**Case Officer:** James Kirkham

**Applicant:** Wroxton College

**Proposal:** Refurbishment and repair of North Arms with Change of Use and conversion of stables into private dining facility and ancillary facilities and underground LPG tank

**Drawing No**  
2016-34/06B

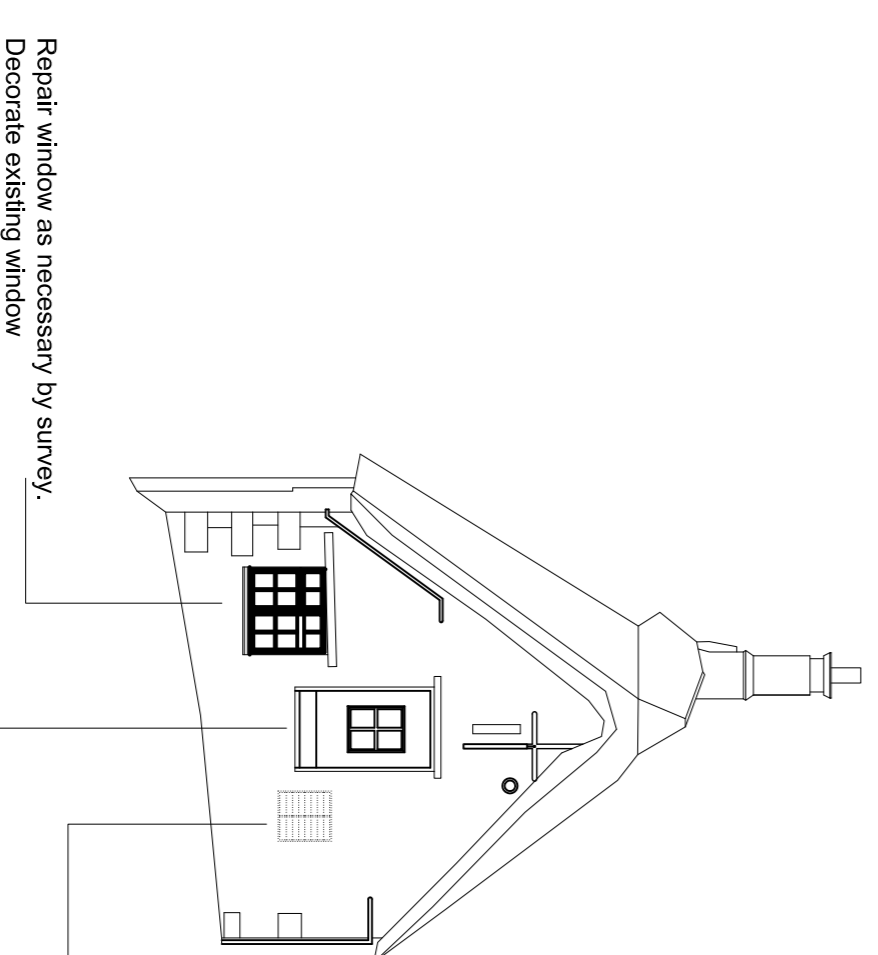
- 8.10. The main concern relating to the principal building relates to the provision of the timber louvred features on the front and rear elevations of the single storey element of the building. When the application was originally submitted it included the kitchen extracts in these louvres as the kitchen is being relocated to this end of the building. During the course of the application, the applicant has revised the plans so that the extract from the kitchen now goes up the redundant chimney breast of the 2.5 storey building (due to noise and odour concerns).

- 8.11. However, the applicant has retained the vents on the roof of the building to provide air intakes to the kitchen. He states this would allow the kitchen to be operate without the windows being open and would reduce noise and disturbance to neighbouring properties in this regard.

- 8.12. The applicant has also amended the design following comments from the Conservation Officer. Whilst these details are not ideal, they are now relatively modest and the Conversation Officer is now satisfied with them subject to detail. It is noted that these elements are proposed on a more modern element of the building and would not adversely impact on the historic fabric of the building. Whilst they would be clearly visible in the street scene, they are not considered to dominate the elevations of the building and would be seen as an ancillary element to the overall building.
